May 15, 2008

**Re: Revised Submission Materials
Portland Museum of Art Spring Street Parking and Garden Project**

As you requested, we submit the attached PDF images of the plans for the Spring Street project. These plans have been revised to include the comments set forth in your memo as well as comments made by the Planning Board at the workshop on May 13, 2008. The specific revisions to the plans are as follows:

Symbol	Label	Qty	Arrangement	Description	Lumens	LLF	Filename
⊙	A	4	SINGLE	DL1-P10-H3-F	9000	0.720	DL1-P10-H3-F.IES
⊙	B1	5	SINGLE	DL1-P10-H4-F	9000	0.720	DL1-P10-H4-F.IES
⊙	B2	1	BACK-BACK	DL1-P10-H4-F	9000	0.720	DL1-P10-H4-F.IES
★	C	12	SINGLE	B-K 'POWER PIPE'

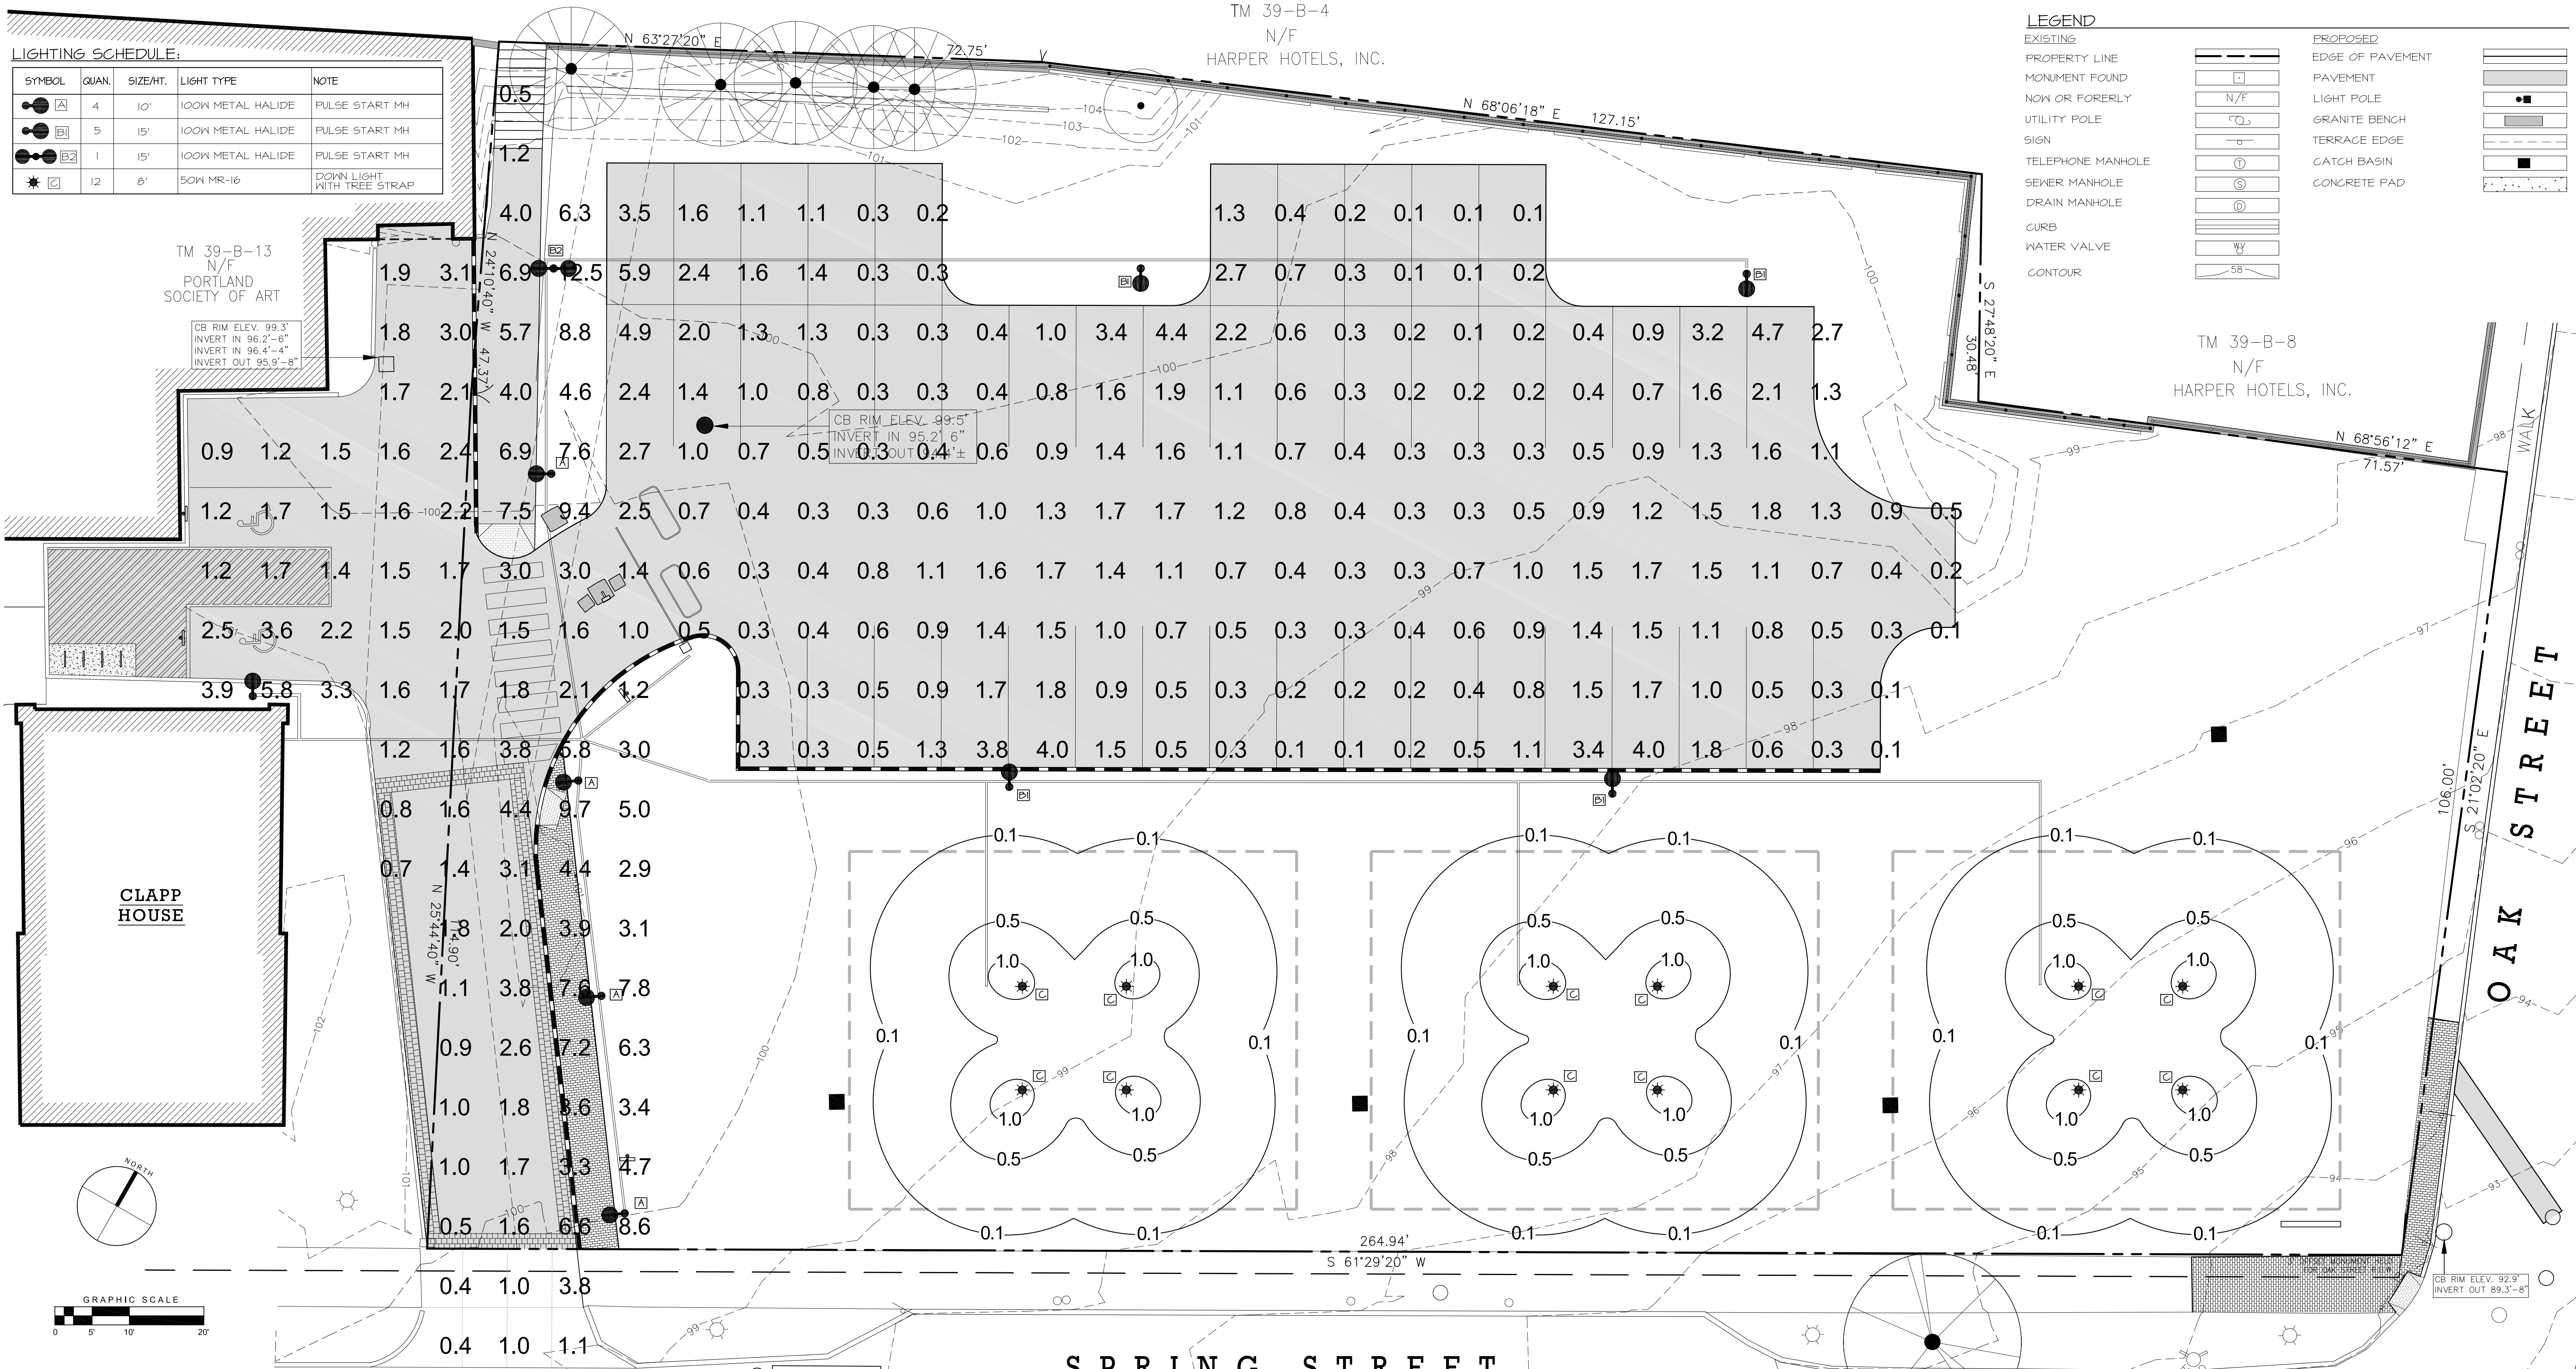
We have revised the lighting plan to address the staff and Board's concerns about illumination levels on the walkway, adjacent to the parking areas, and within the landscaped terraces. The bollard lights have been replaced with 100-watt pole-mounted lights at a 10-foot height parallel to the walkway. The light pole locations within the lot have been adjusted to provide more even illumination levels. After exploring several options the lighting for the landscaped terraces will consist of four (4), 50-watt downlights located on each of the three terraces. The downlights will be mounted at an 8-foot height and will be angled downward at 45 degrees. This lighting will provide a well dispersed, low-level of light within the center of each bosque of birch trees. The revised photometric plan will be sent to you under separate cover as we waiting for it to be completed.

**L4.0**

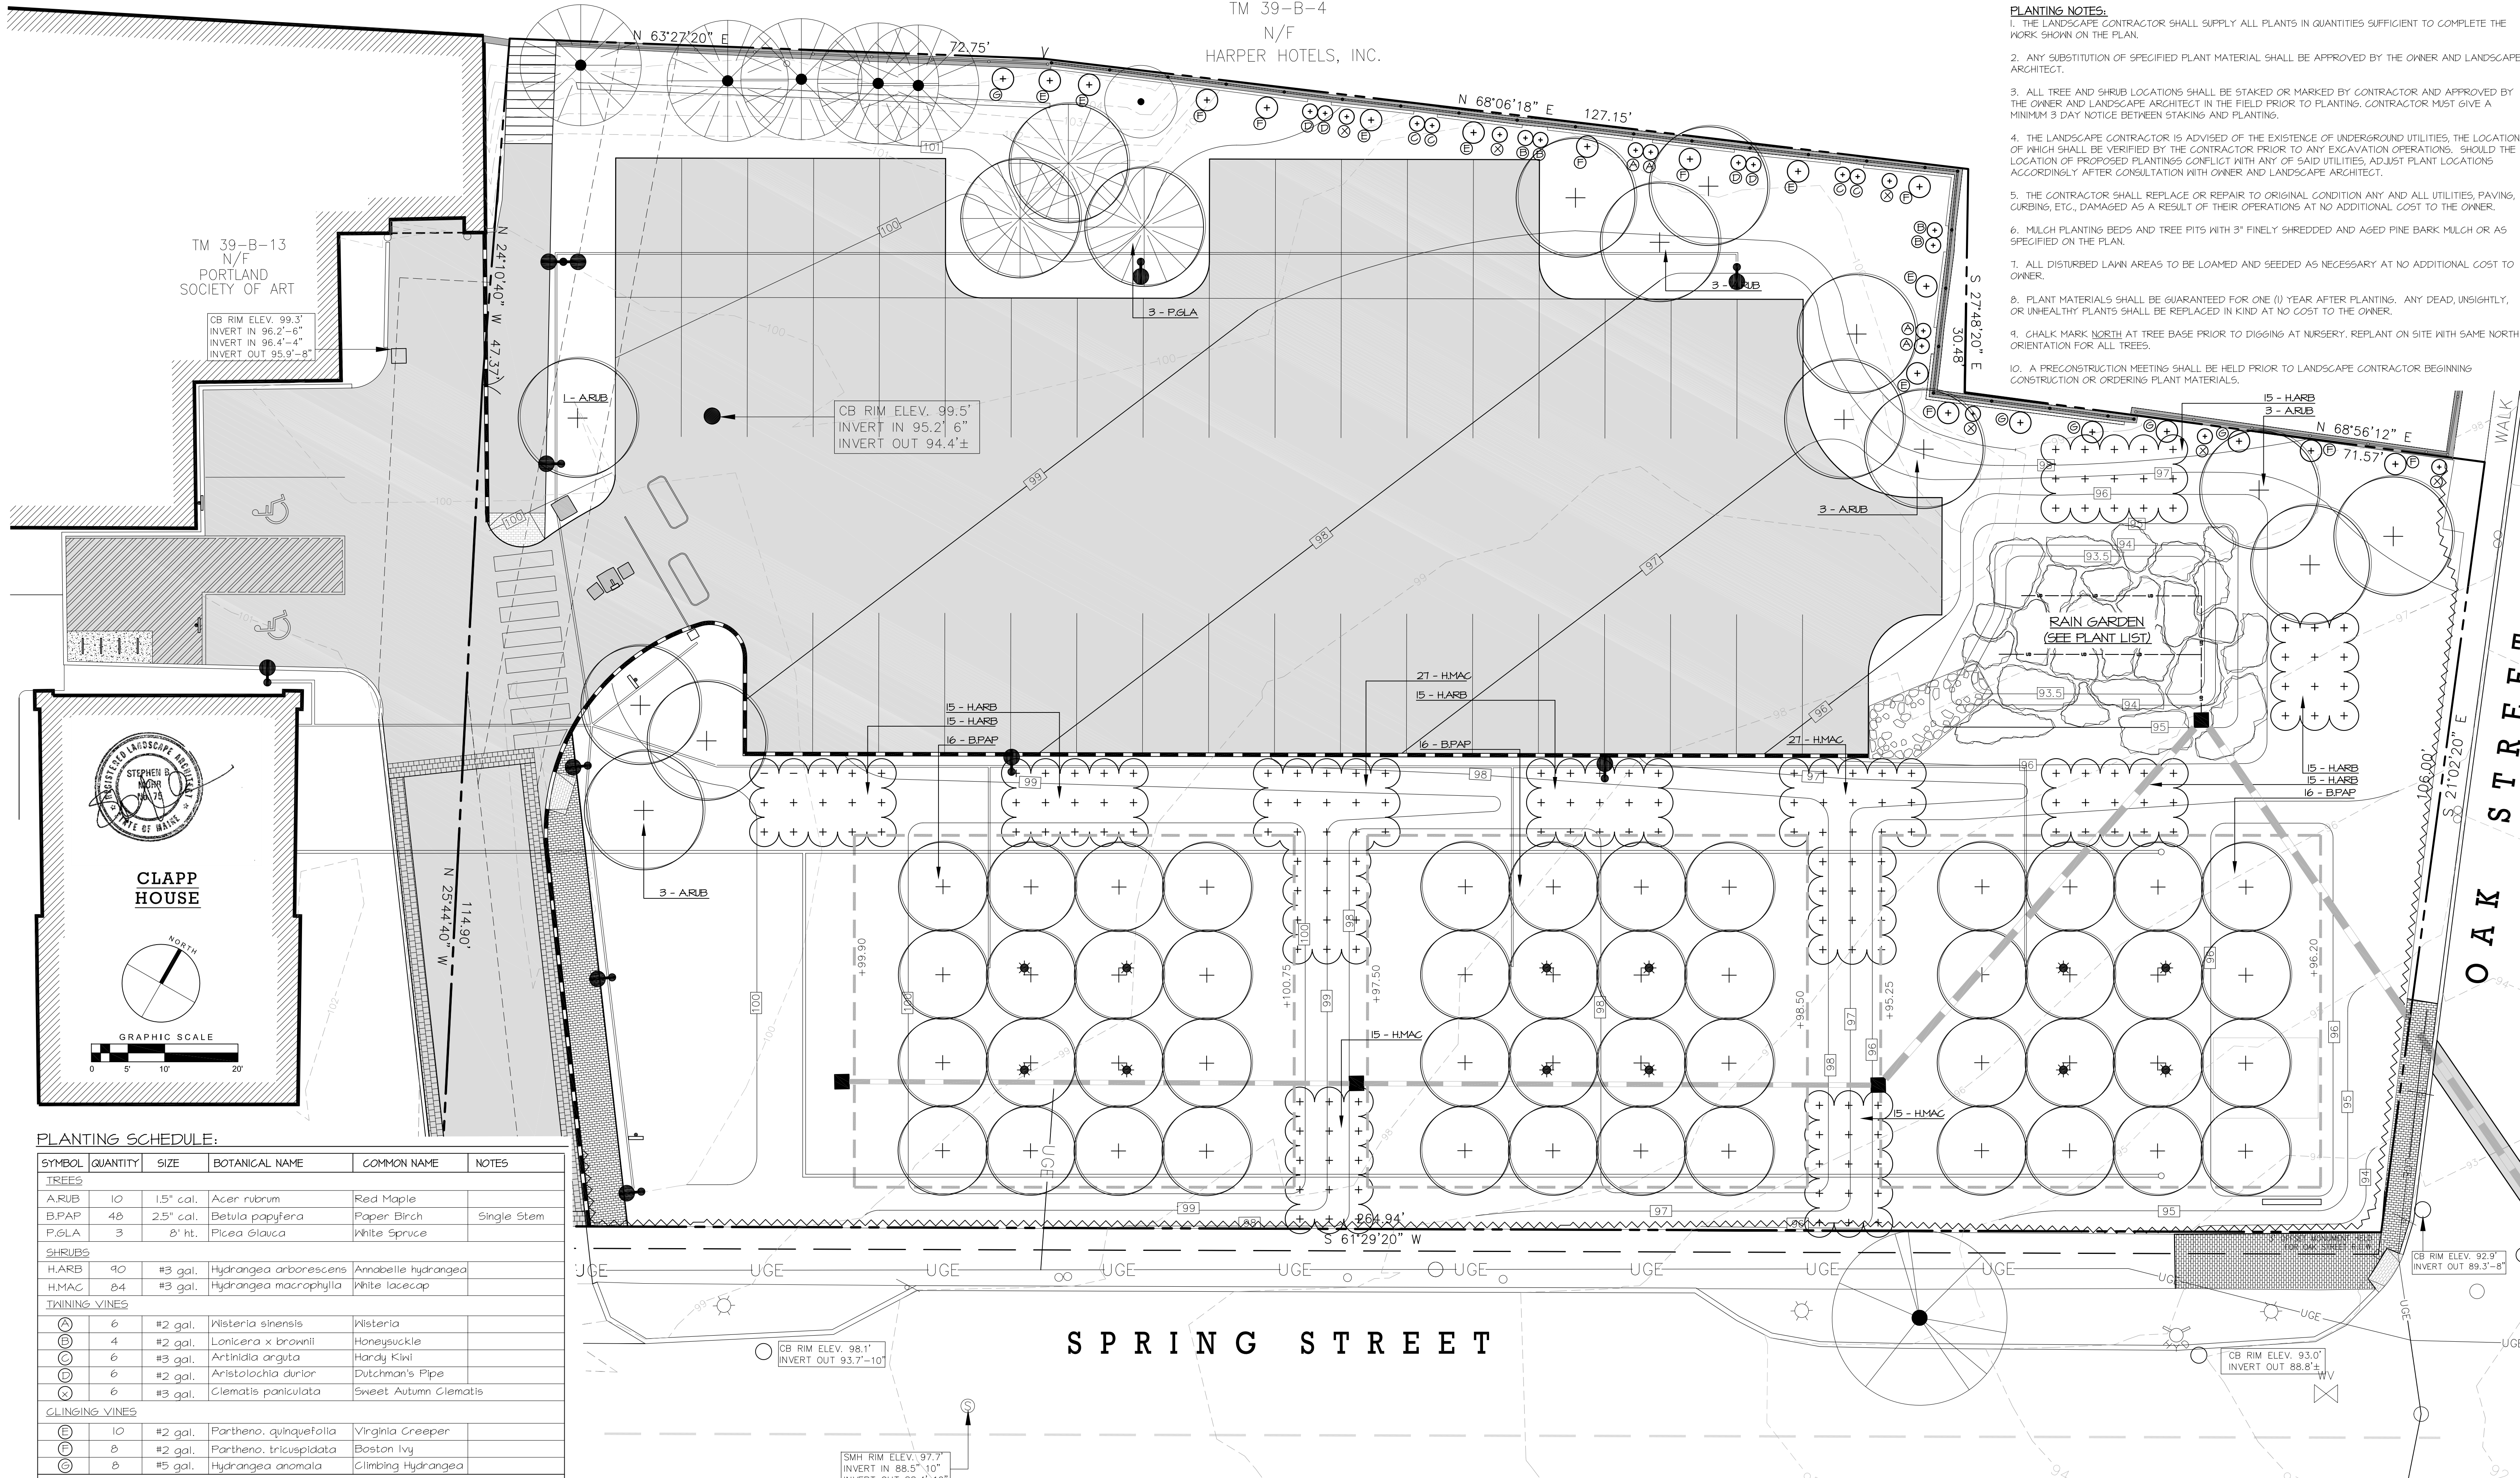
4. **Planting:**
As discussed with the City Arborist, and reviewed with the Planning Board, we have added an additional vine species, Sweet Autumn Clematis, to the plant list for the rear wall. We have also increased the plant quantities and increased plant

sizes for some of the vines. These changes are shown on drawing L4.0 and are noted in the plant list included on drawing L4.0. All other plantings remain as previously shown on the plans.

7 CITY OF PORTLAND BRICK SIDEWALK/CURB DETAIL  
L5.1 NOT TO SCALE

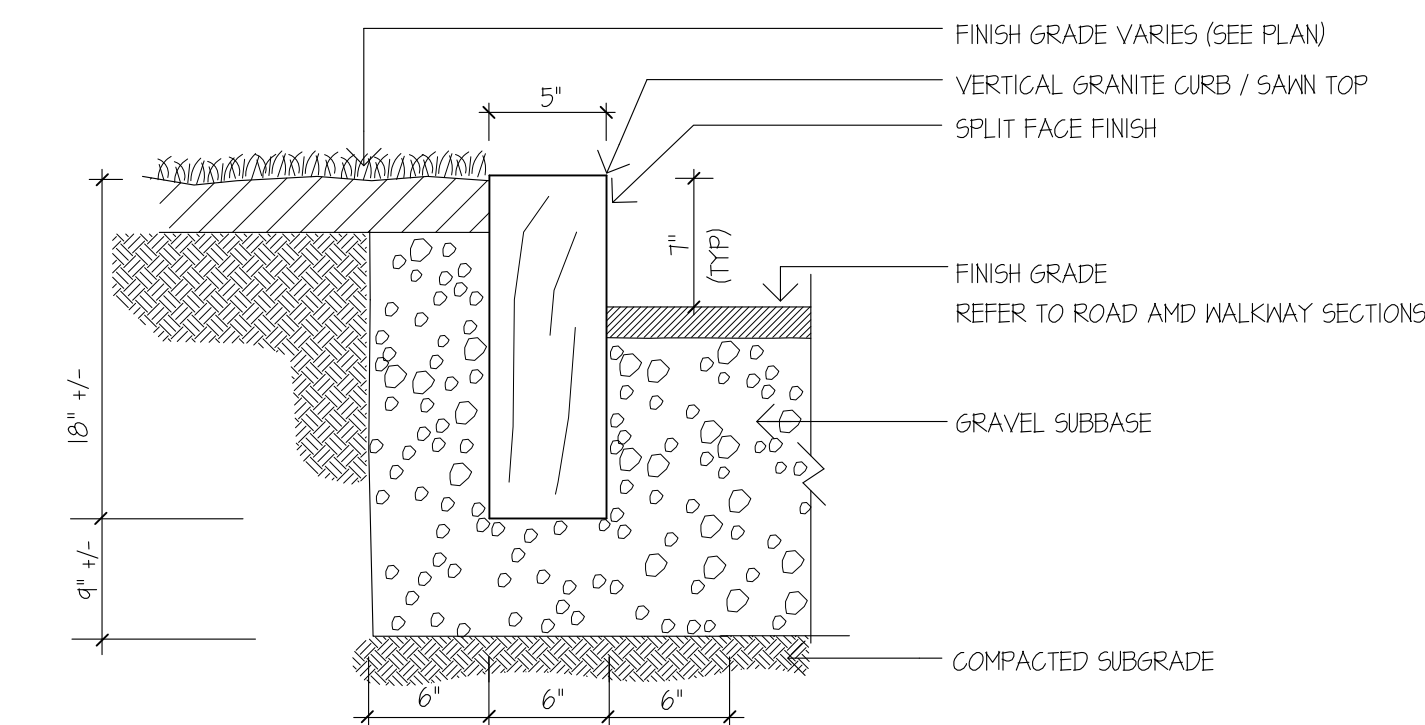
2. **Sidewalk repairs and improvement in Spring and Oak Streets:**
We have included on our plans the information showing the extent of the sidewalk repair and improvements on Oak and Spring Streets. The work limits are in conformance with Mr. Farmer's memo. We are replacing the concrete sidewalks with brick as is required in this district. The details are shown on the project detail sheet.

6 PARKING LOT / ACCESS CONTROL GATE  
L5.2 NOT TO SCALE

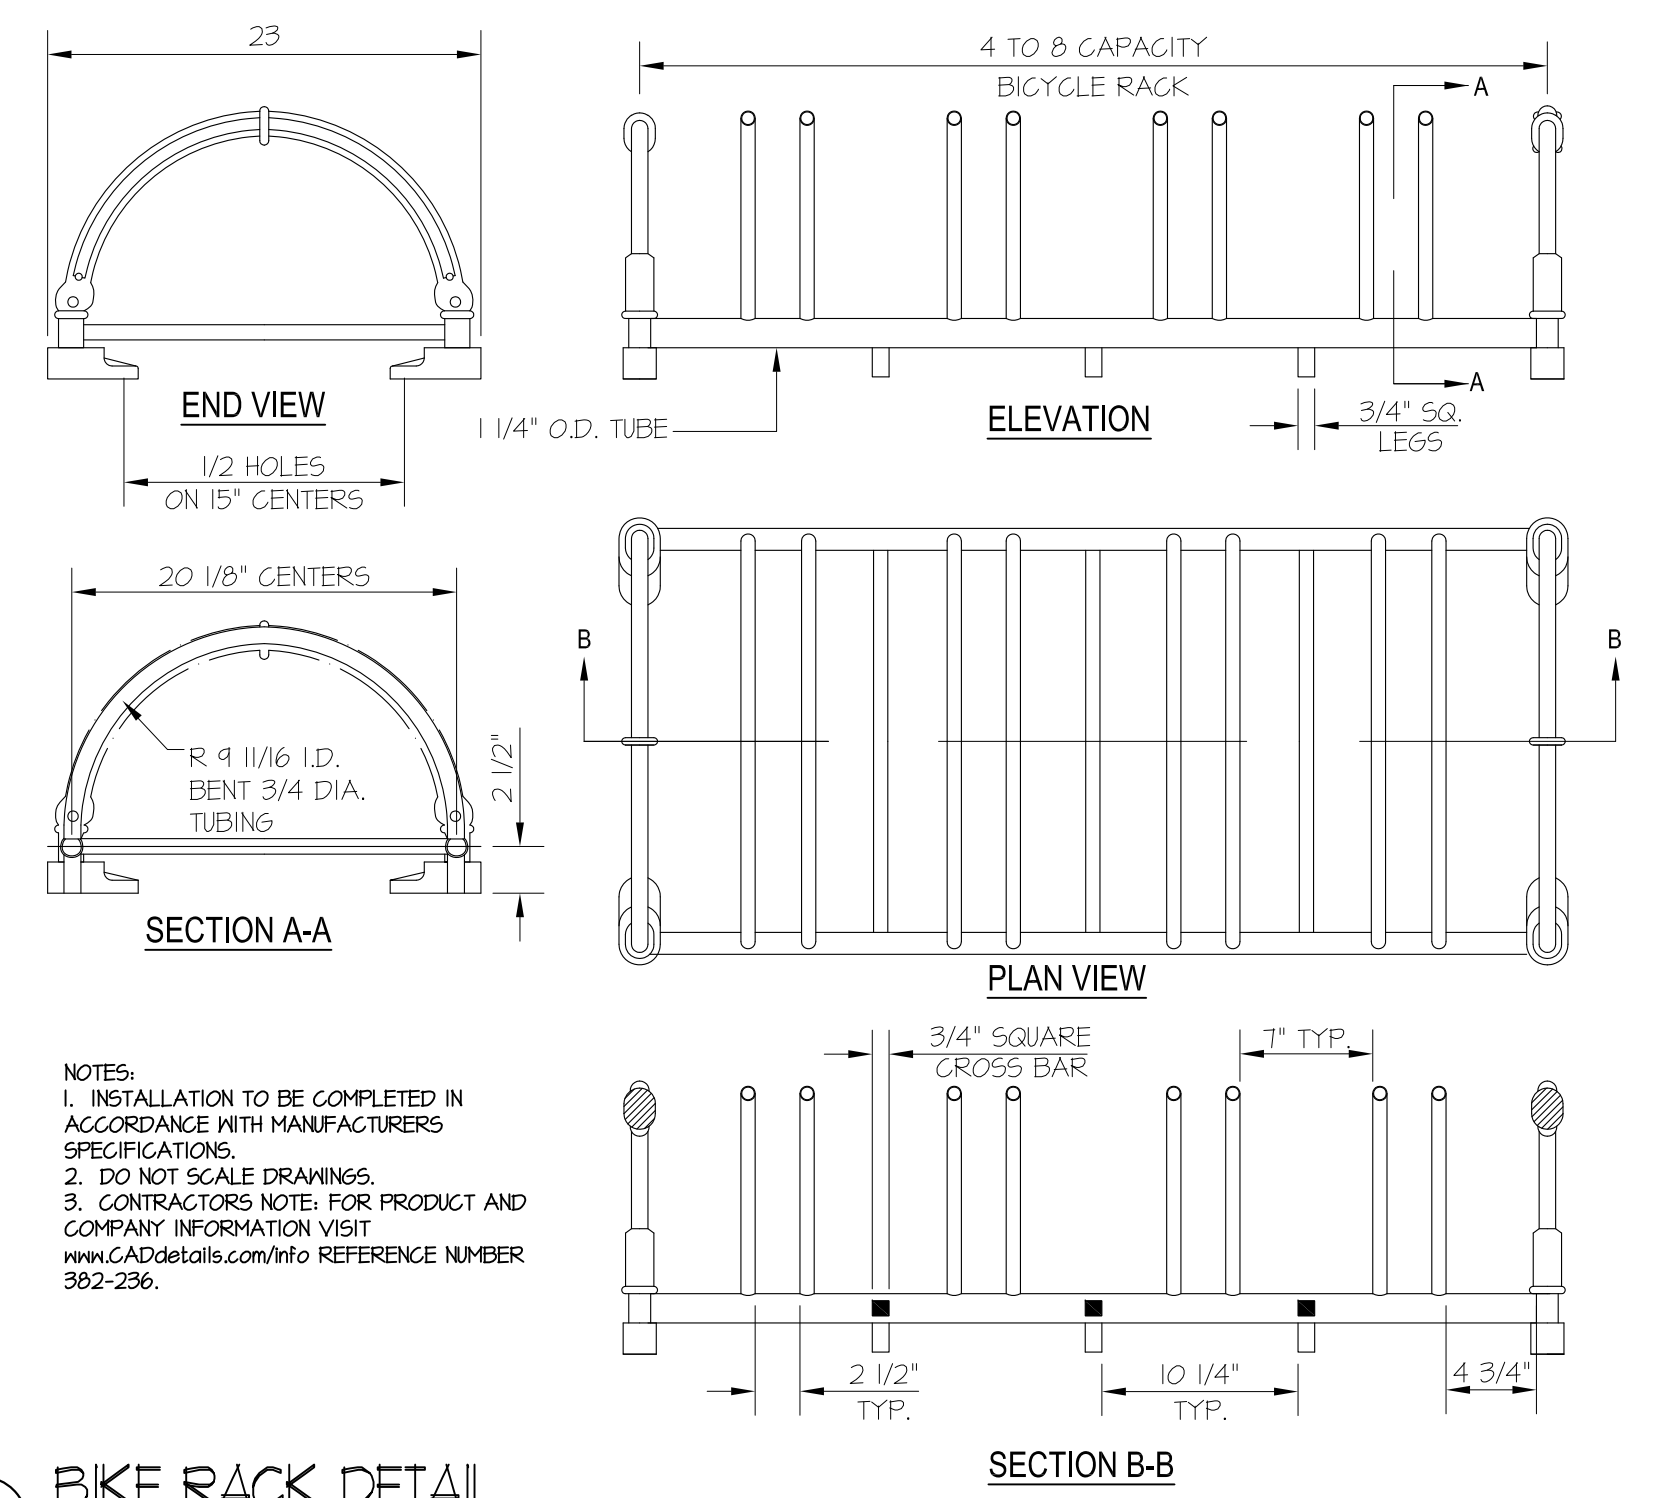
1. **Electronic gate for parking control:**
The plans have been revised to include an electronic gate and 18-foot long control arm. The gate has been located to control access into, and out of, the new parking lot. The gate is designed with both a key pad and magnetic swipe card so that access will be limited to the persons set forth in our earlier correspondence. The control key pad has been located on a granite block on the drivers' side of the entry aisle for ease of convenience. The details for the control gate are included on the detail sheet for the project.
